**KIRKLEES METROPOLITAN COUNCIL
INVESTMENT & REGENERATION SERVICE**

DELEGATED DECISION TO DETERMINE PLANNING APPLICATIONS

Reference No: 2019/62/92391/E

Site Address: Greenways, Granny Lane, Lower Hopton, Mirfield,
WF14 8LA

(20)001

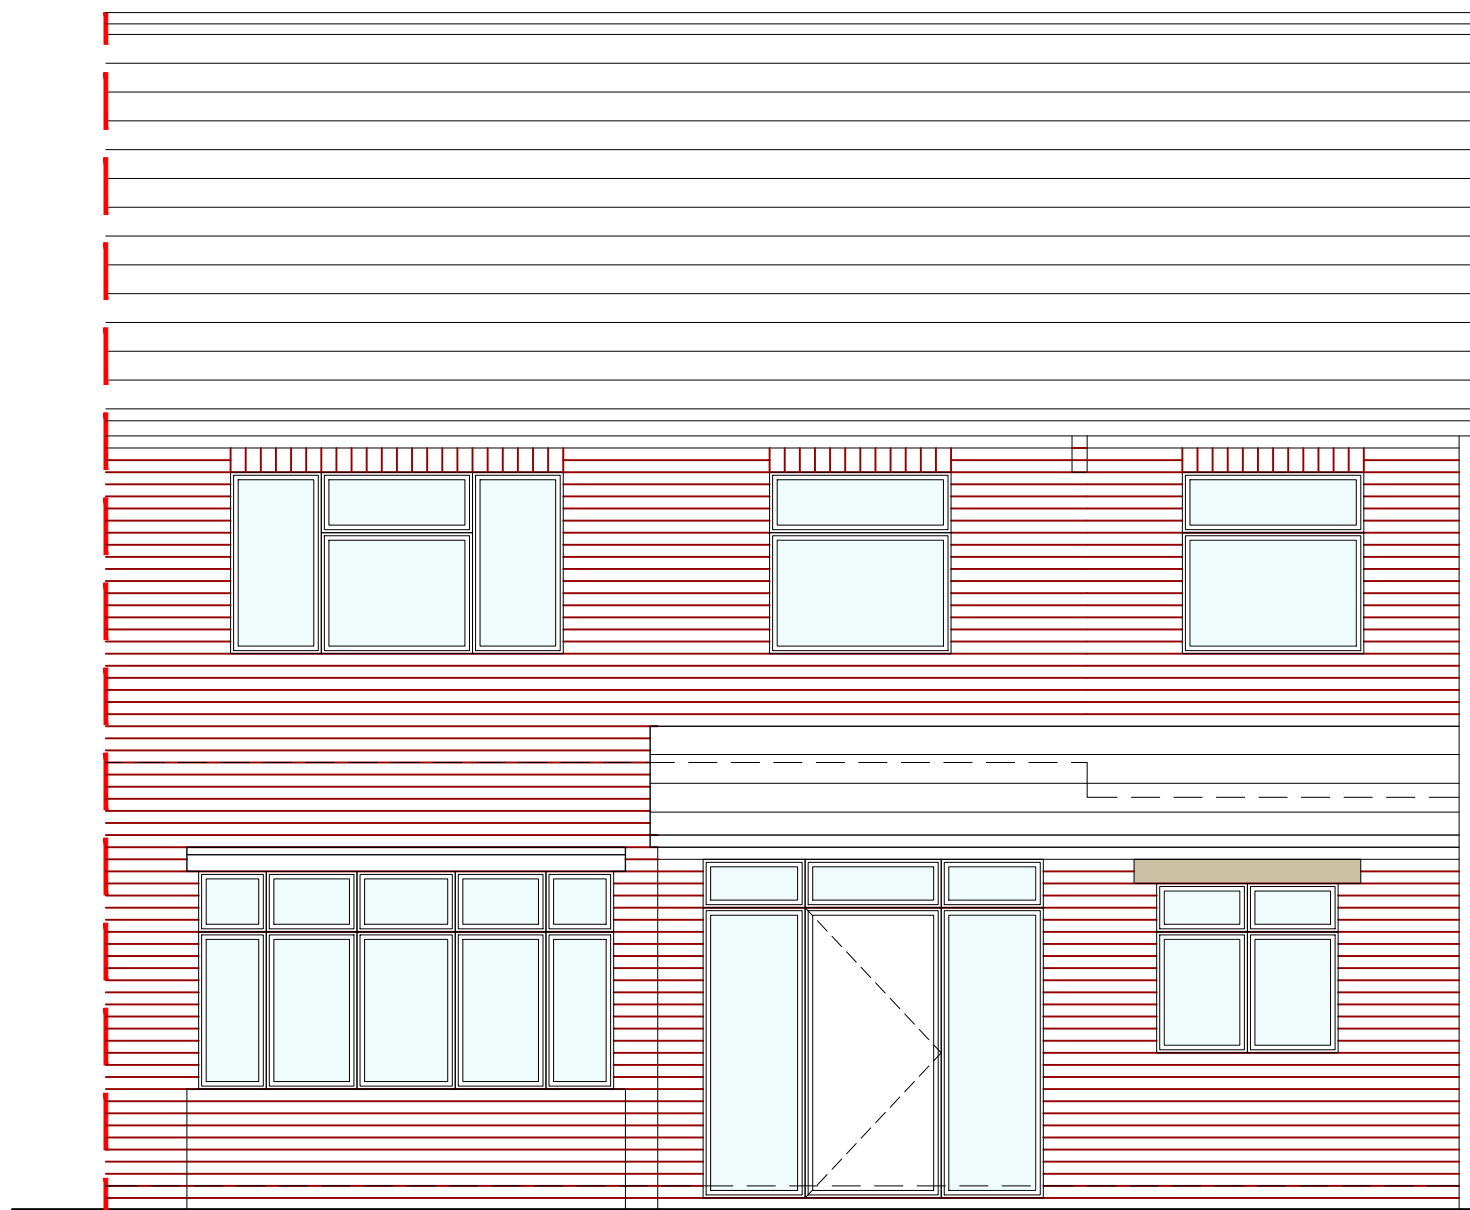
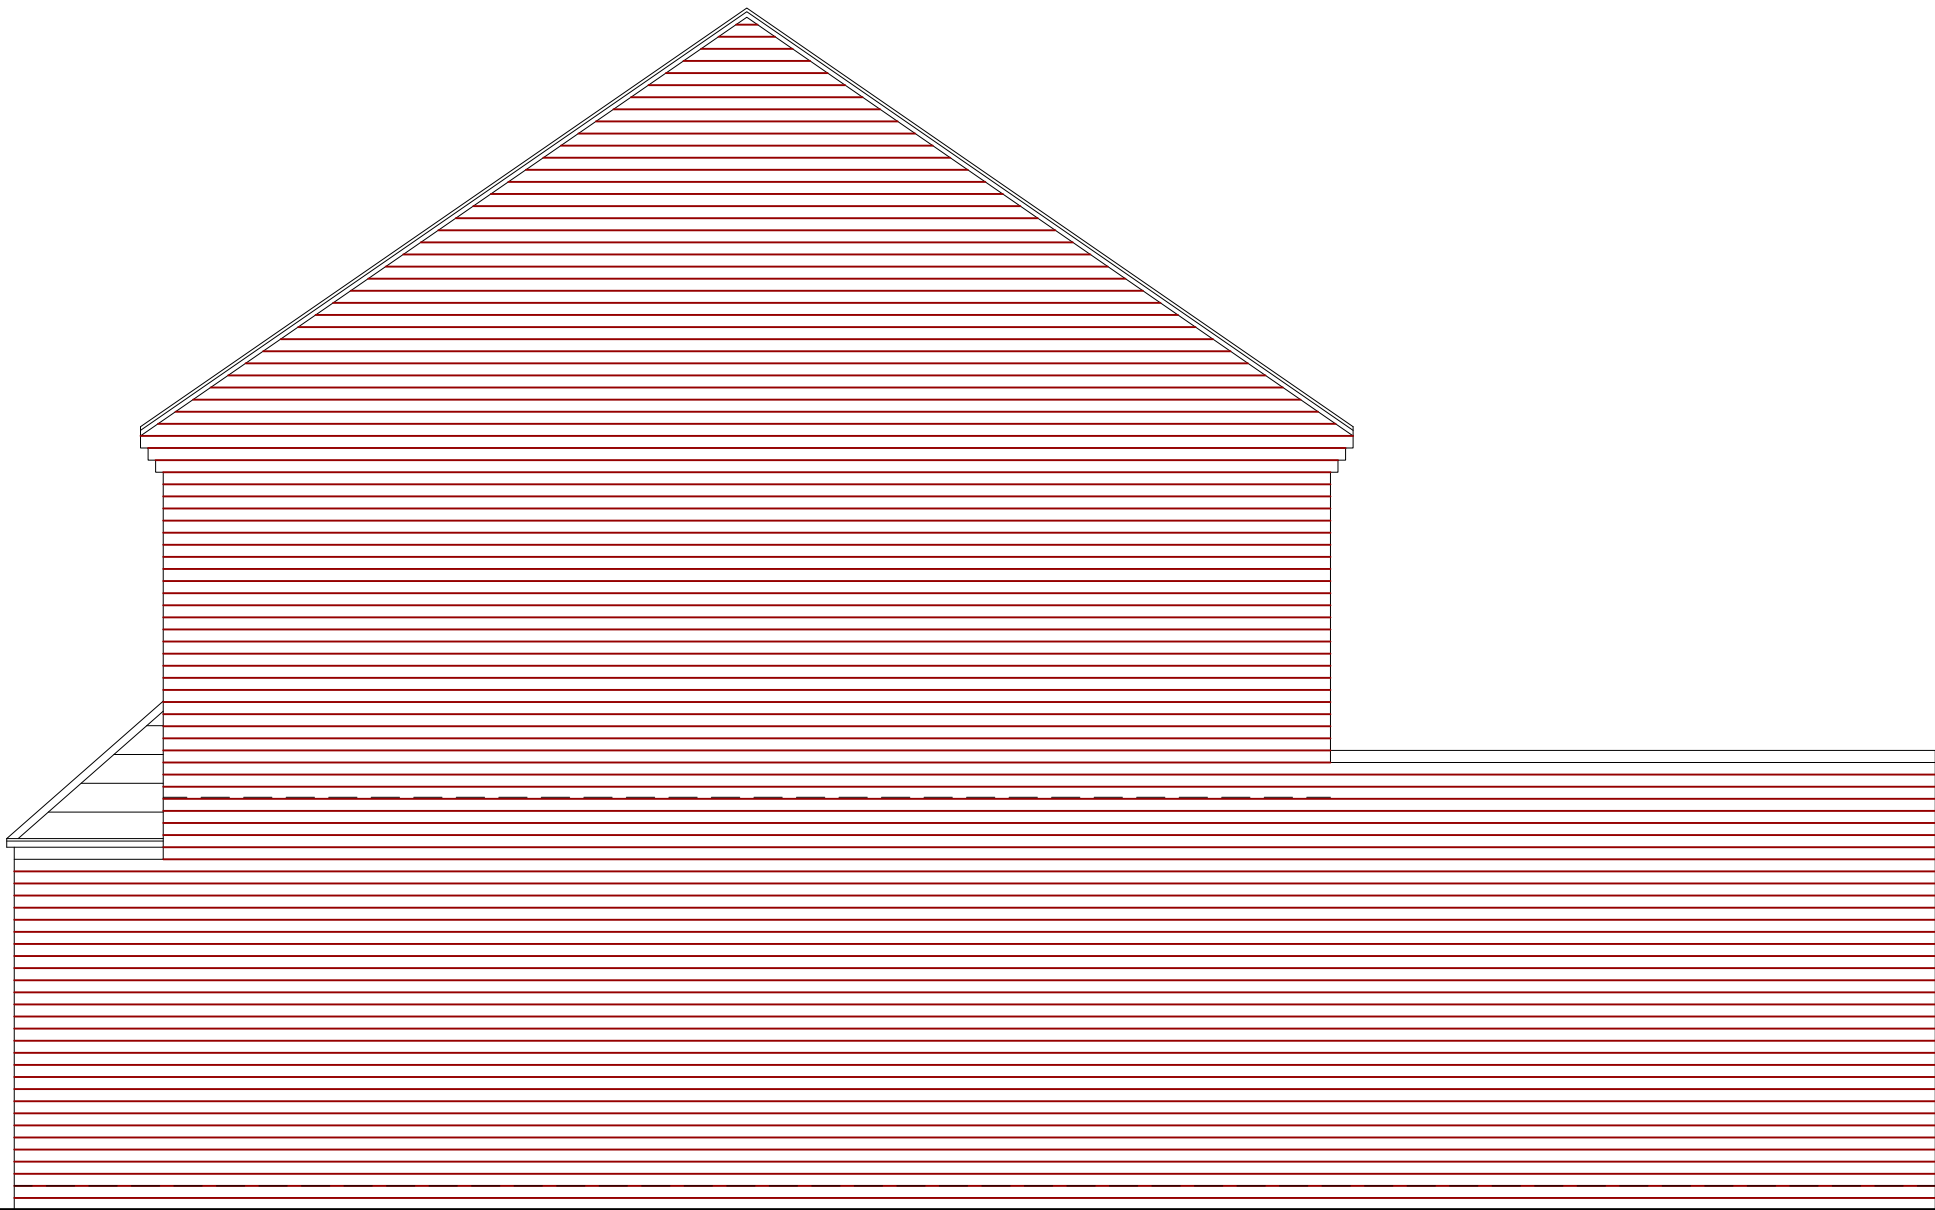
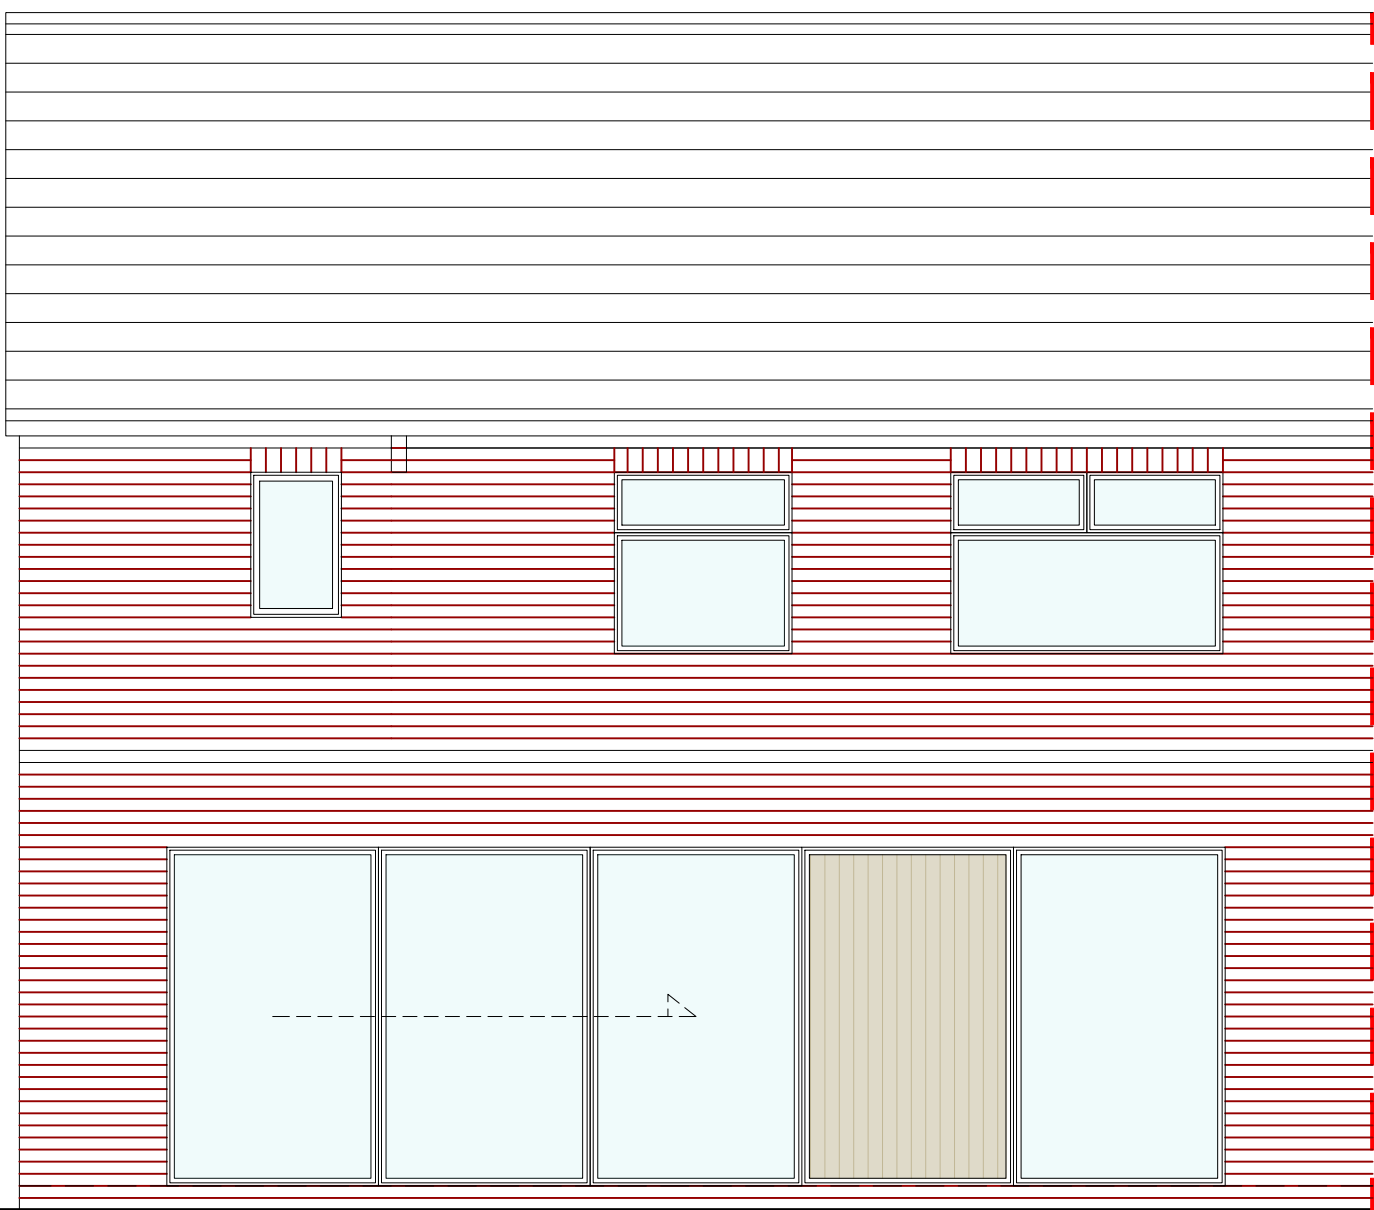
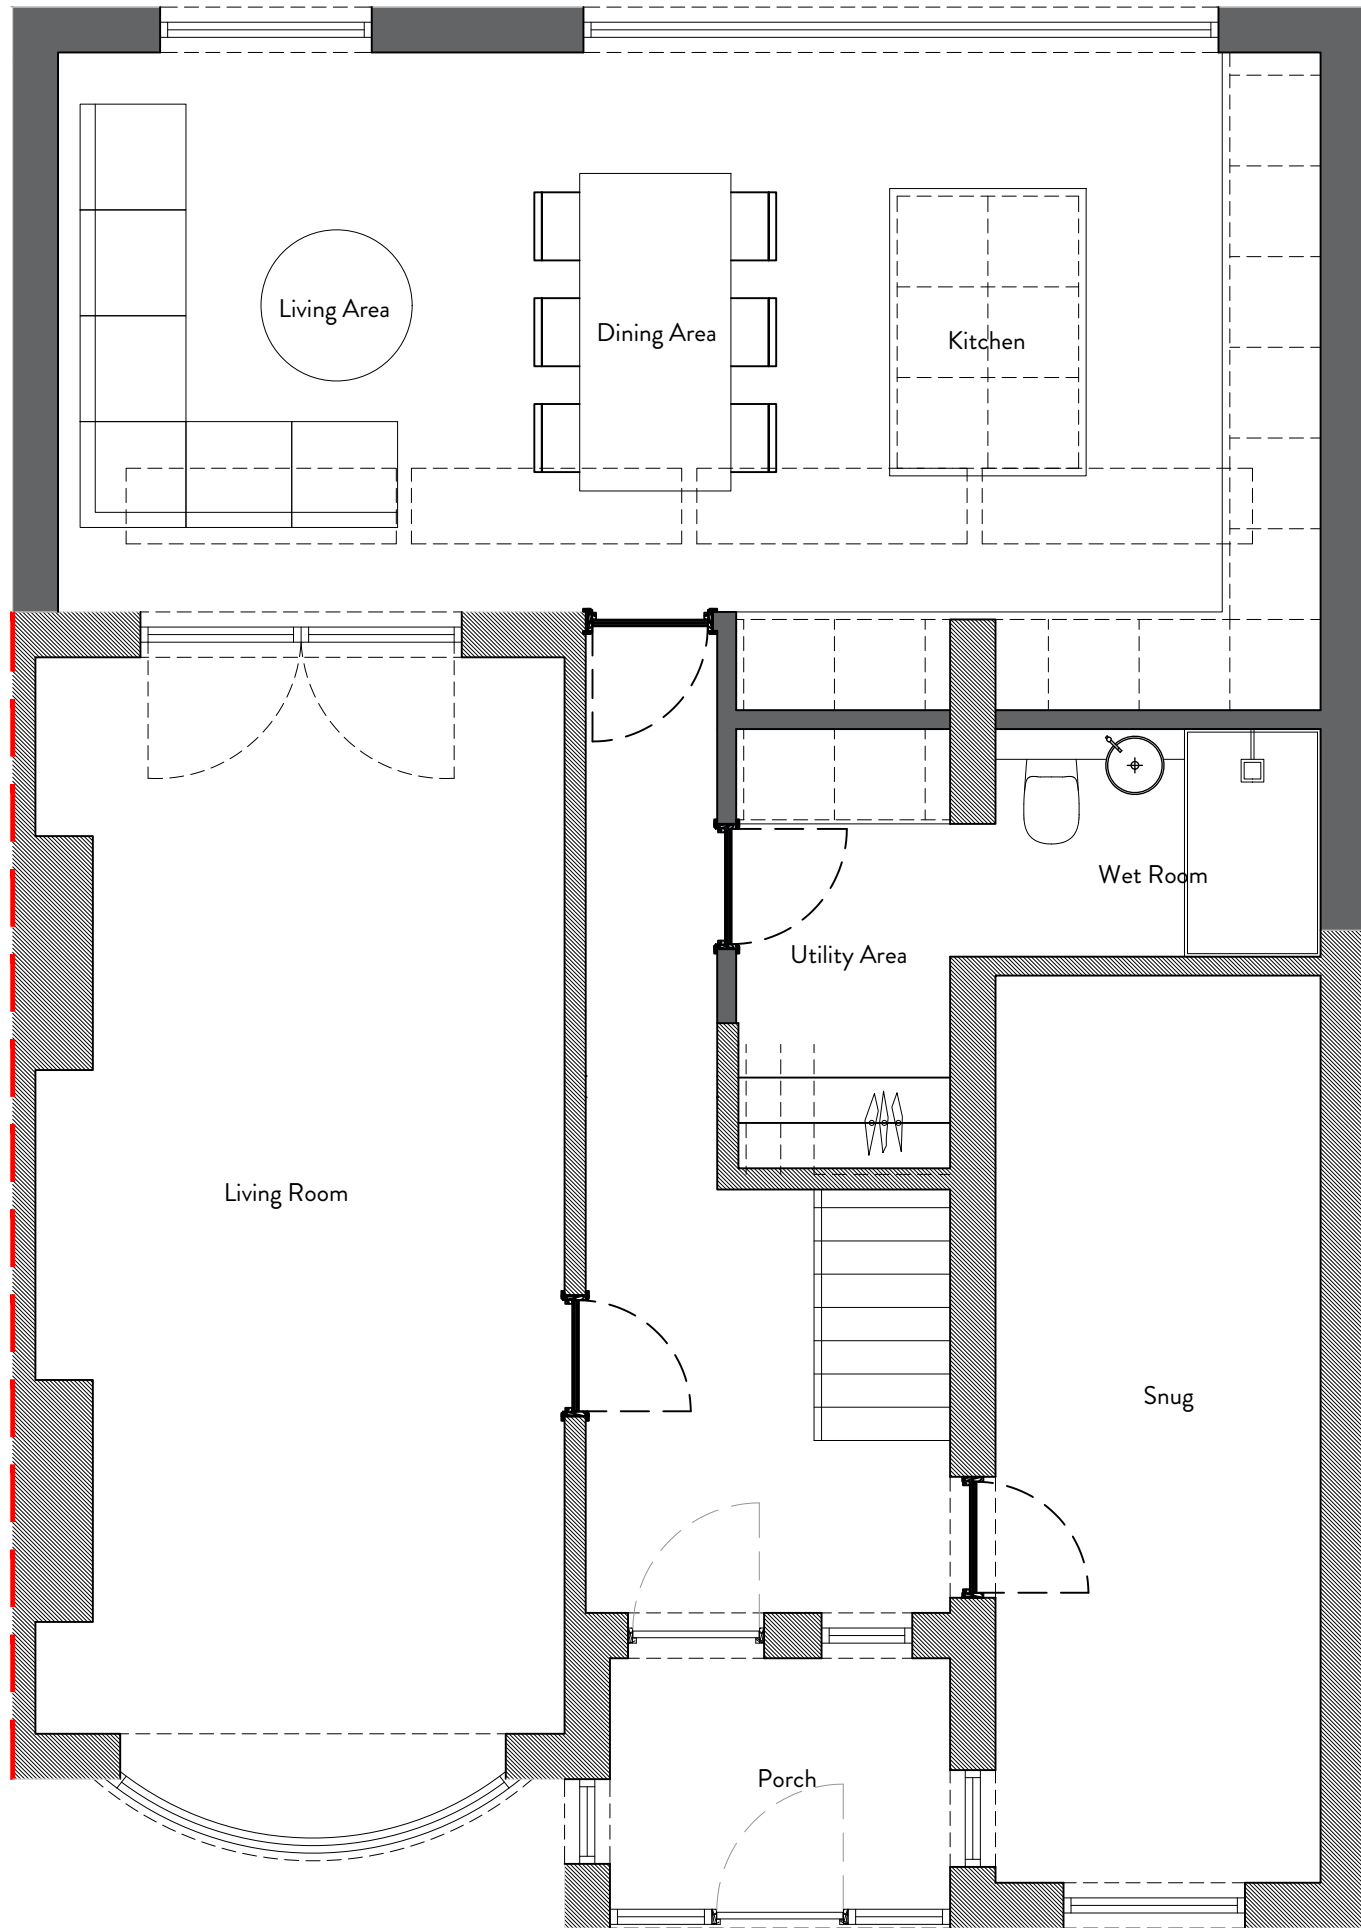
Concern was raised regarding the projection of the proposed rear extension along the boundaries shared with both the adjoining and adjacent properties. Amendments were also sought to the proposal to set the eaves and ridge height of the proposed two storey extension down from that of the host property to prevent the development from creating a terracing effect.

Amended plans were received from the agent reducing the projection of the rear extension from the proposed two storey extensions to 1.00 metre. Whilst the extension would still project 4.00 metres along the boundary shared with the adjoining property, given the height of the extension, its location to the west of the property and existing boundary treatment, this is considered, on balance, to be acceptable. The openings on the rear elevation have been altered to include a window, a door and bi-folding doors which would extend round to the western elevation of the extension where it would be set in from the boundary.

The amended plans show the eaves height of the extension set down from existing by 0.10 metres and the ridge height by 0.15 metres.
